Our ref: DOC19/593947
Senders ref: MP 06_0079

CiviLake Construction and Green Waste Facility - Modification MP 06_0079 MOD 1 The Weir Road, Teralba

BCD has reviewed the *Modification Report for CiviLake Construction and Green Waste Recycling Facility, The Weir Rd, Teralba* dated June 2019 prepared by KDC Pty Ltd on behalf of Lake Macquarie City Council in relation to biodiversity, Aboriginal cultural heritage, and water, flooding and coastal management impacts.

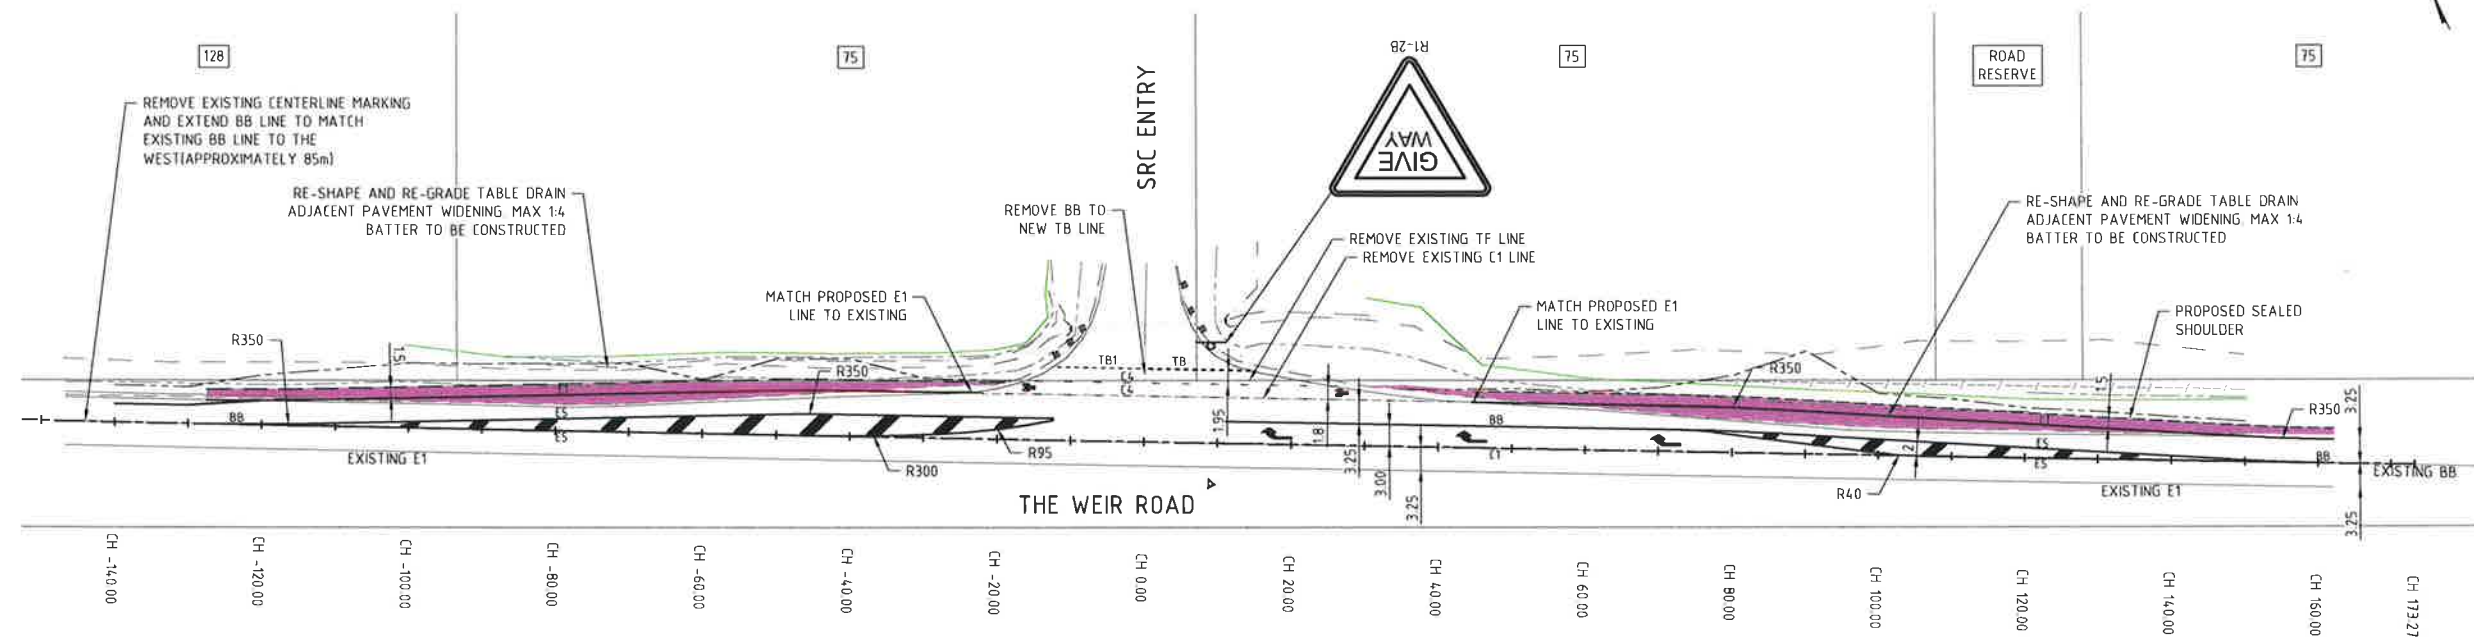
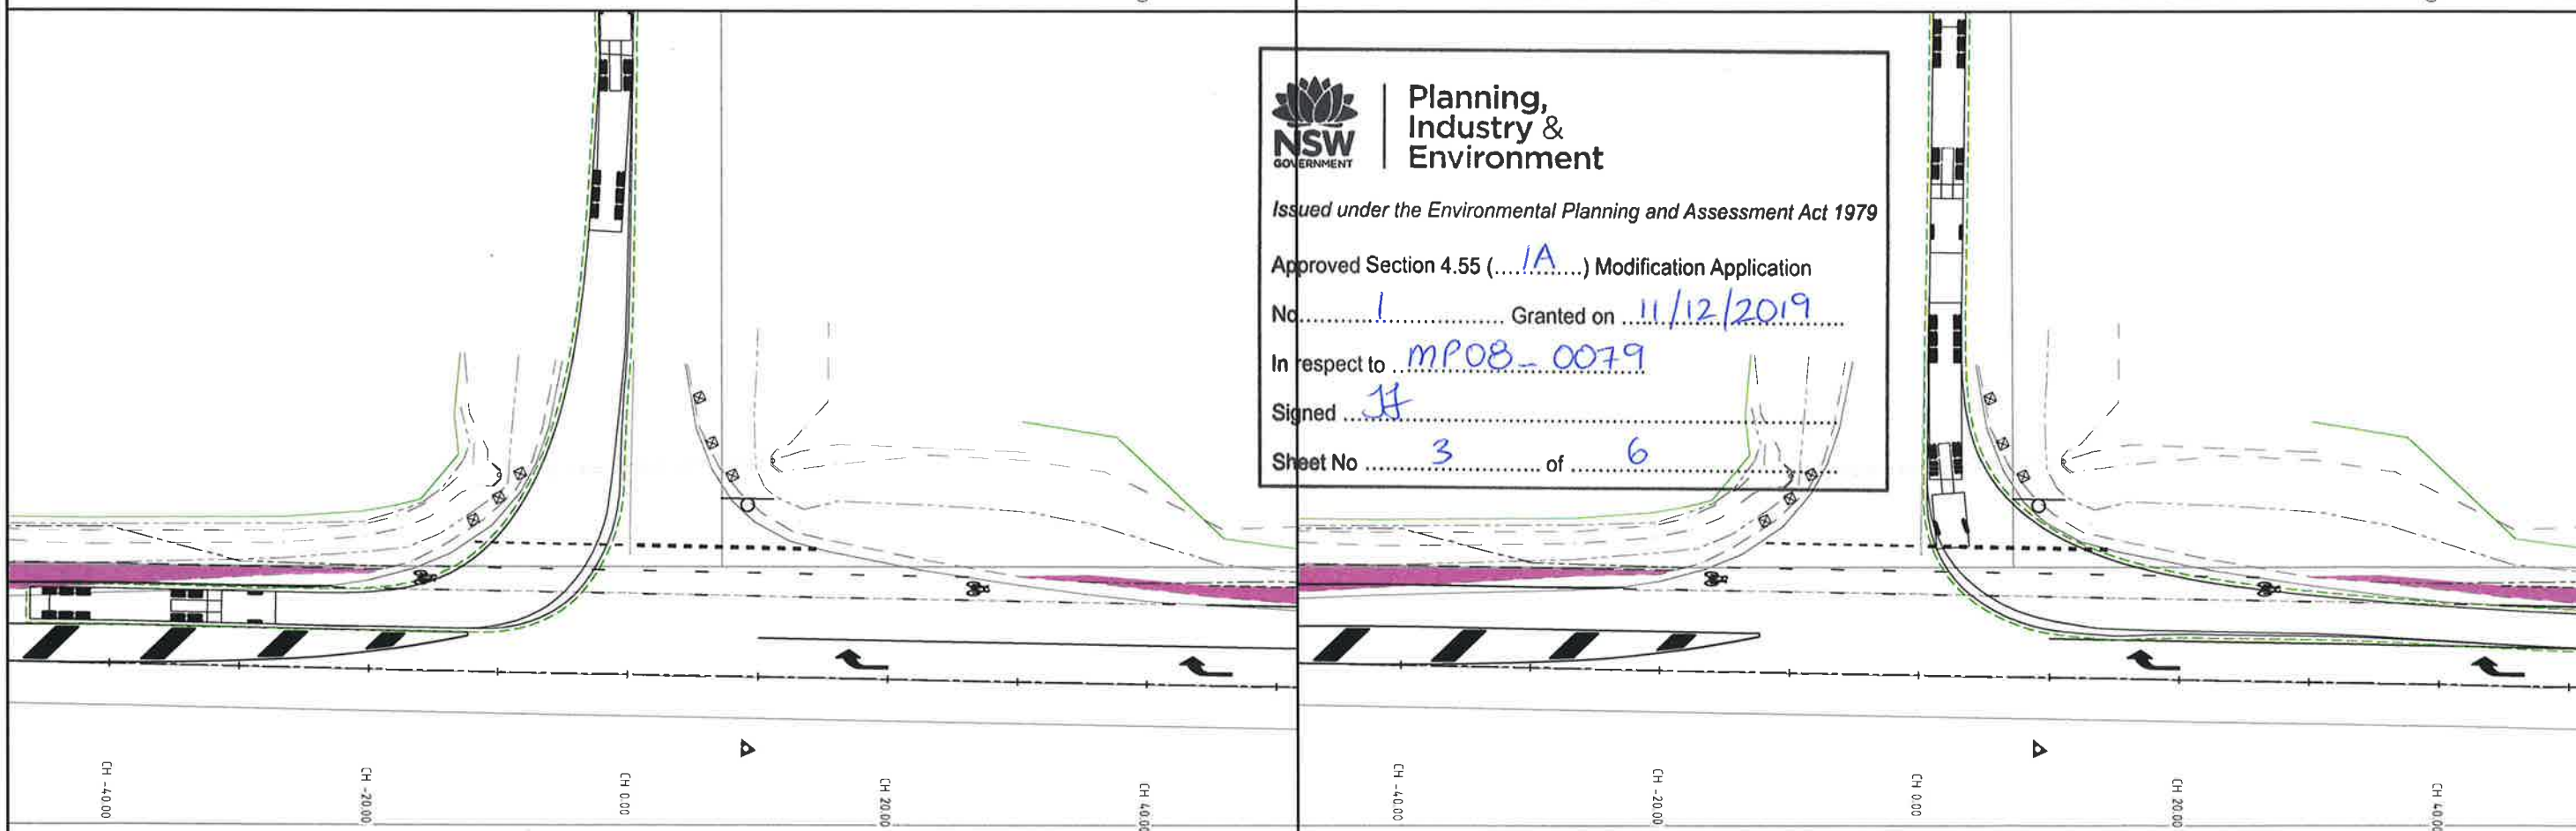
The Modification Report (MR) has provided a plan that shows road widening and a new intersection type at the entrance of the proposed Construction and Green Waste Facility to improve access and safety. The MR has not determined whether there will be any removal of vegetation involved with the road widening. The proposed road widening is in proximity to an Endangered Ecological Community, Swamp Schlerophyll Forest on Coastal Floodplains under the *Biodiversity Conservation Act 2016*. A Biodiversity Development Assessment Report (BDAR) may be required if the vegetation to be removed triggers the Biodiversity Offsets Scheme.

The Modification Report (MR) for the proposed new intersection at the entrance of the existing Teralba Recycling Facility, Weir Road, Teralba, also known as the Teralba Green Waste Recycling Facility (the Facility), requires widening of the existing Weir Road at the entrance of the Facility. Proposed ground disturbance road works include pavement widening, grading of soils, construction and shaping of batters and the sealing of the road shoulder. The MR does not contain sufficient detail to determine the likely level of impact on Aboriginal cultural heritage in the vegetated areas on either side of the road and intersection.

BCD recommends that an Aboriginal cultural heritage assessment is undertaken for the proposed disturbance area to determine the potential impacts or harm that road construction works may have on Aboriginal objects or sites within the modification area. The Aboriginal archaeological and cultural heritage values for the proposed modification should be documented. The identification of cultural heritage values should be guided by the [*Guide to investigating, assessing and reporting on Aboriginal Cultural Heritage in NSW \(DECCW, 2011\)*](#) and consultation with Aboriginal people must be undertaken and documented in accordance with the [*Aboriginal cultural heritage consultation requirements for proponents 2010 \(DECCW\)*](#).

A Biodiversity Development Assessment Report (BDAR) may be required if the vegetation to be removed triggers the Biodiversity Offsets Scheme.

BCD recommends that an Aboriginal cultural heritage impact assessment is conducted to determine the potential impacts or harm that road construction works may have on Aboriginal objects or sites within the modification area.
